21 July 2016

Site 9 Sydney Olympic Park, 3 Olympic Boulevard proposed residential development. Expert Judgement related to BASIX alterations

A 4 bedroom penthouse is located on Level 39 of the tower and is accessed by a fourth lift serving levels 38 and 39. Provision has been made for for hot water, AC condenser and stair pressurization plant to be located on the Level 39 rooftop.

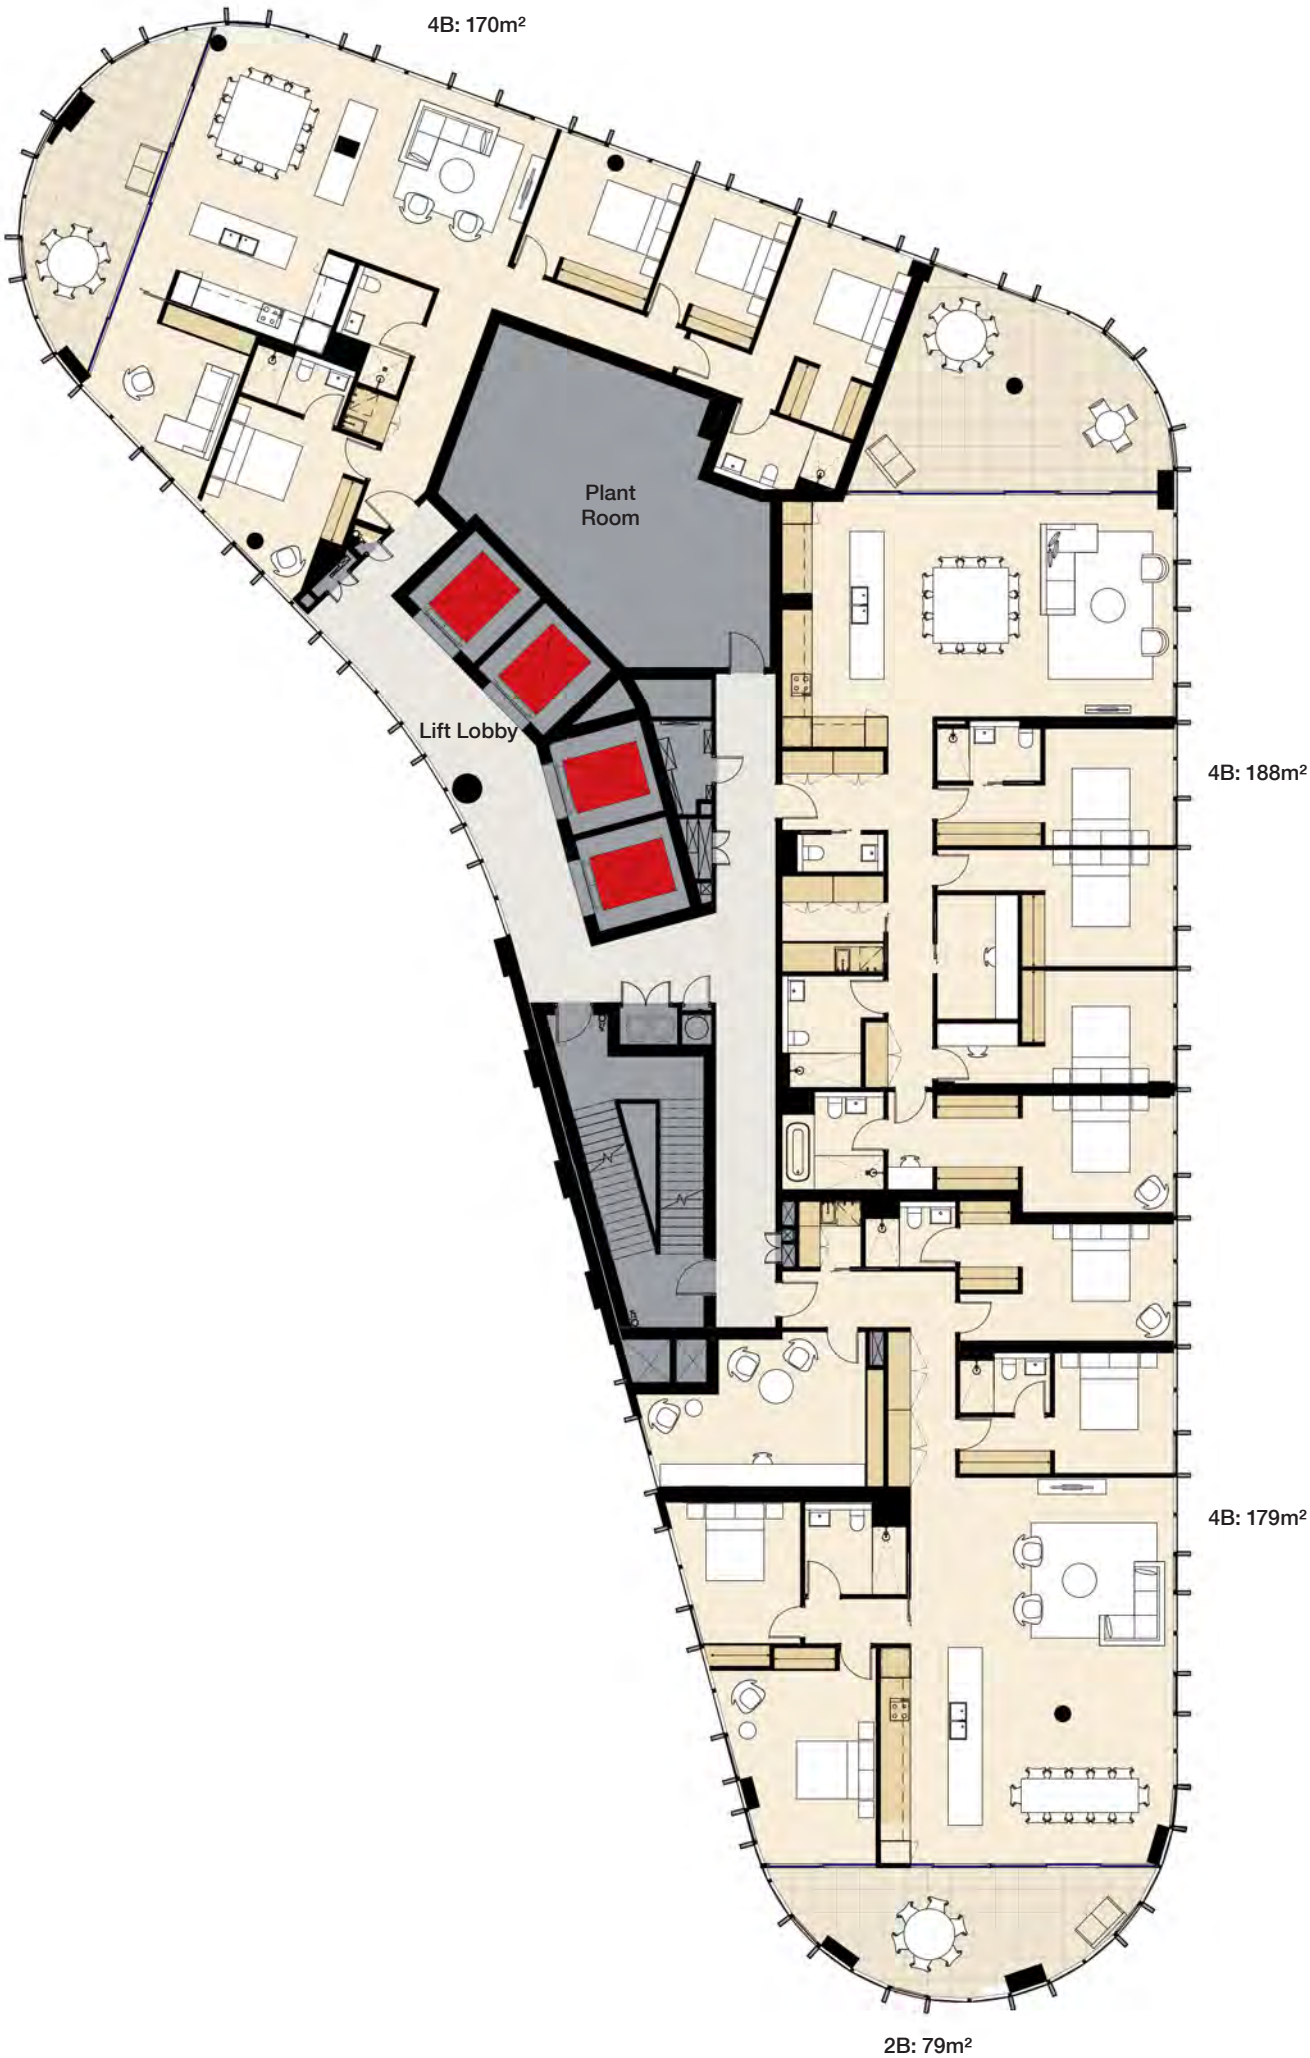
- The key issue is that the Penthouse BASIX thermal comfort performance. The level 39 Penthouse apartment is large but the glass/ area to floor area in similar to the other apartments at approximately 30% glass area ratio to floor area.
- The main north east elevation and the narrow living room is favourable to passive winter heating which will reduce the BASIX winter energy requirements.

- The large overhang shade on the north elevation will allow the penetration of welcome winter sun but will eliminate summer sun.
- The glazing for the façade will need to be a low e double glazing potentially with thermal breaks to improve the overall U value of the façade system. The solar performance (SHGC) of the glass will need to be assessed but we believe it will be a realistic range of SHGC 0.3 to 0.5.
- The deletion of the one north facing apartment to accommodate bicycle storage will not impact the overall BASIX performance.

Overall the alterations will not impact the BASIX energy and water performance and the glass to the Penthouse will have to be assessed using the comfort tool to select the appropriate U value and SHGC performances required for BASIX compliance. The BASIX certificates will need to be revised prior to the Construction Certification stage of the project.
